Dogger Bank South Offshore Wind Farm

Appendix E6 to the Natural England Deadline 6 Submission
Natural England's comments and updated advice on Fish and Shellfish

Planning Inspectorate Reference EN010125

13th June 2025

Figure: 2.1	Drawing No:	
Co-ordinate system: WGS 1984 UTM Zone 30N	Page Size: A3	Scale: 1:850,000
Project:  Dogger Bank South Offshore Wind Farms	Report:

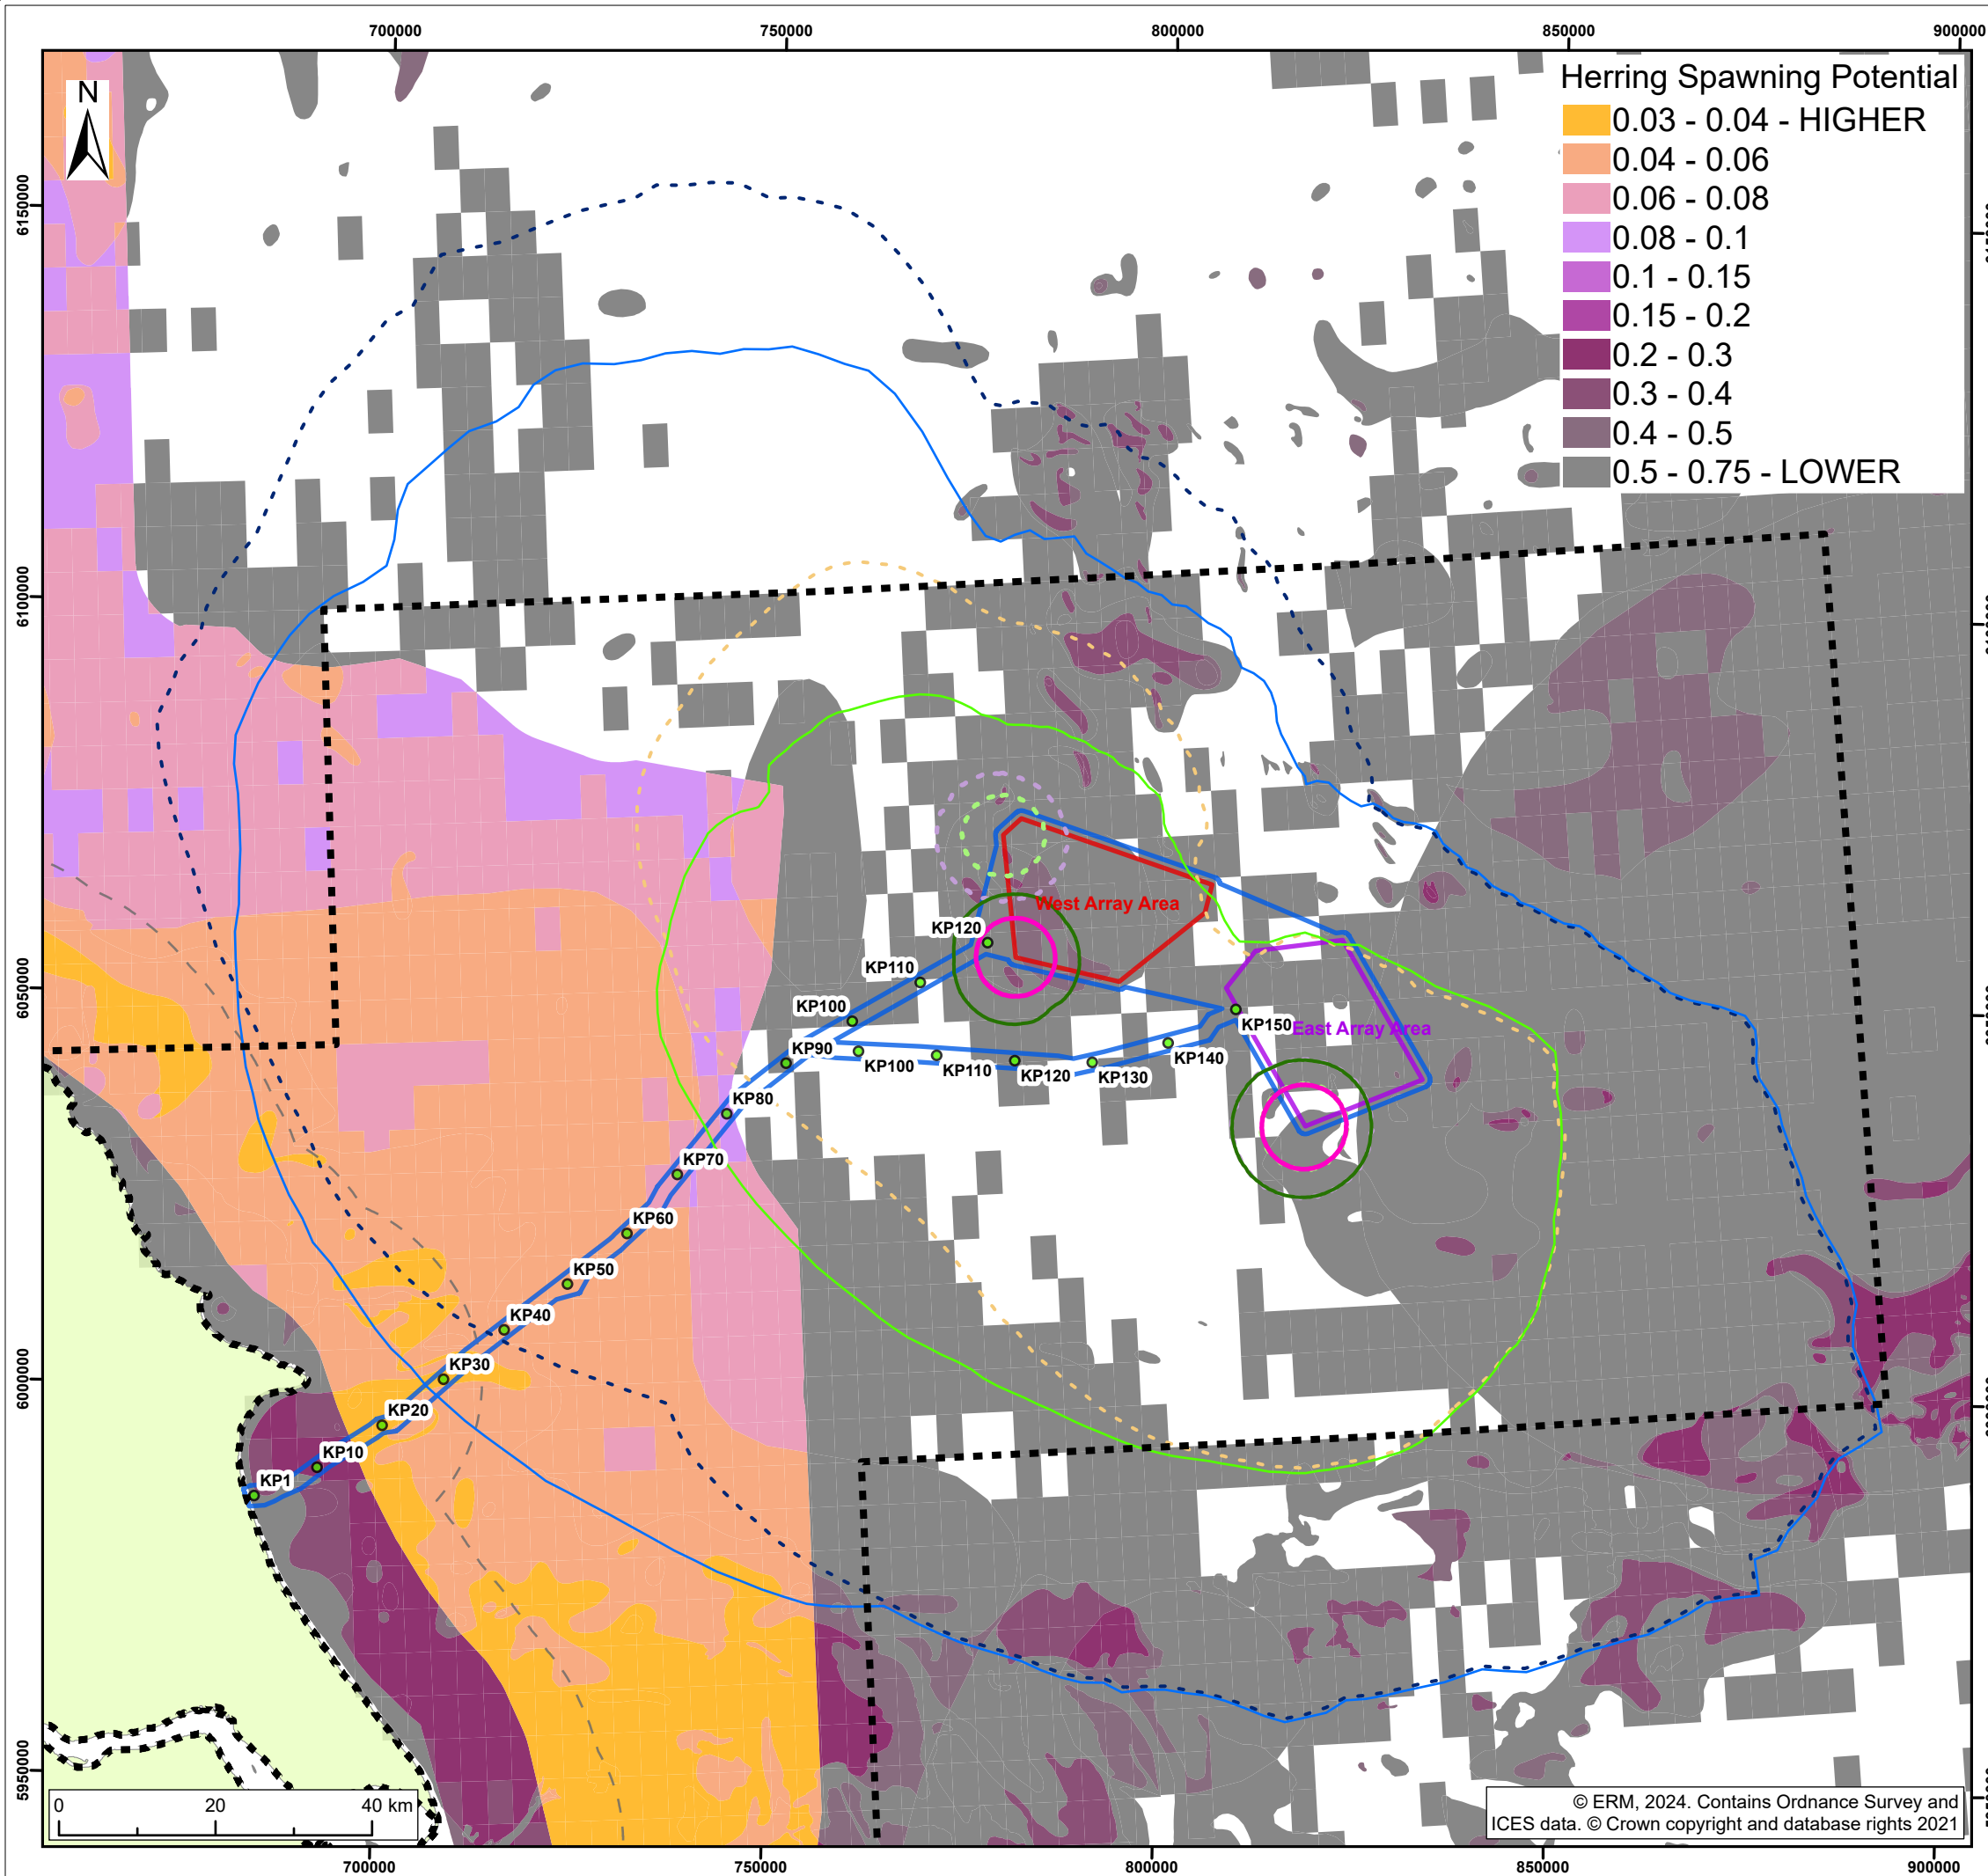
Natural England welcome the Applicant’s provision of the updated modelling in [REP5-042]. This modelling demonstrates that, should concurrent piling occur across the two arrays in the southwest corner of the DBS West array and the south location of DBS East, the area of overlap between underwater noise impacts and high potential herring spawning habitat would be approximately double that when using the locations assessed in the original worst-case scenario (WCS; increasing from 14.38% to 30.41%, using the 135 dB contour). The impacts also encompass a larger area of preferred substrates, both closer to the coastline and to the north of the arrays within the 135 dB behaviour contour. With the 135 dB contour moving 10-20 km south, this also brings it into closer proximity of the seabird colony at Flamborough and Filey Coast Special Protection Area.

We also welcome that the Applicant has included the outputs with a 10 dB reduction applied as a result of underwater noise mitigation. This greatly reduces the area of overlap with high-moderate potential spawning habitat and eliminates the overlap with very high potential herring spawning habitat. However, Natural England’s Deadline 5 advice [REF5-056] remains that whilst the illustration of the 10 dB reduction is welcomed, until the Applicant commits to delivering this reduction through the application of primary and/or secondary mitigation, we cannot currently deem the impacts on fish to be resolved.

Natural England have discussed the results with respect to the WCS for the arrays in-isolation and in-combination below, and advise that the Environmental Statement assessment for herring should be updated to reflect the revised piling locations. Acknowledging the limited time remaining in Examination, we would welcome discussion with the Applicant on what is practicable.

Based on the results presented, Natural England disagrees with the Applicant's view that this '*does not represent a change in the worst-case scenario*'. We acknowledge that the WCS originally assessed was selected to maximise the spatial extent over which underwater noise could impact fish receptors as defined in Popper et al, (2014). However, we consider this report demonstrates a more appropriate WCS of the impacts of the arrays in-combination on herring specifically. As noted by the Applicant, "*it is reasonable to expect that these areas [spawning habitat] coincide with an increased population of adult Atlantic herring during the spawning period. It would be these increased populations of adult fish that would, therefore, be potentially susceptible to impacts from underwater noise*". This would also be in-keeping with Natural England's advice for consideration to be given to population specific impacts with respect to indirect effects [REF5-056].

The Applicant has acknowledged that modelling two monopile locations within a single array area would represent the realistic WCS for the in-isolation build out scenario, however one monopile was modelled in each array as they considered it would be more precautionary by maximising the spatial extent of impacts [REP5-033]. Natural England raised concerns about this approach in our Relevant Representations [RR-039] and advised that a WCS should be provided for each build-out scenario; for underwater noise and vibration impacts this would be two simultaneous monopile piling events in the DBS West array area. Whilst this advice was originally provided in the context of sandeel, the Applicant's inclusion of the previously modelled DBS West west location alongside the DBS West south-west location in Figures 2.1 and 2.3 of the updated modelling [REP5-042] has provided a visual representation of this WCS for herring. The figures demonstrate that under this WCS, there would be a greater overlap of the 135 dB contour with high-moderate suitability herring spawning habitat than the current WCS of one monopile in each array.
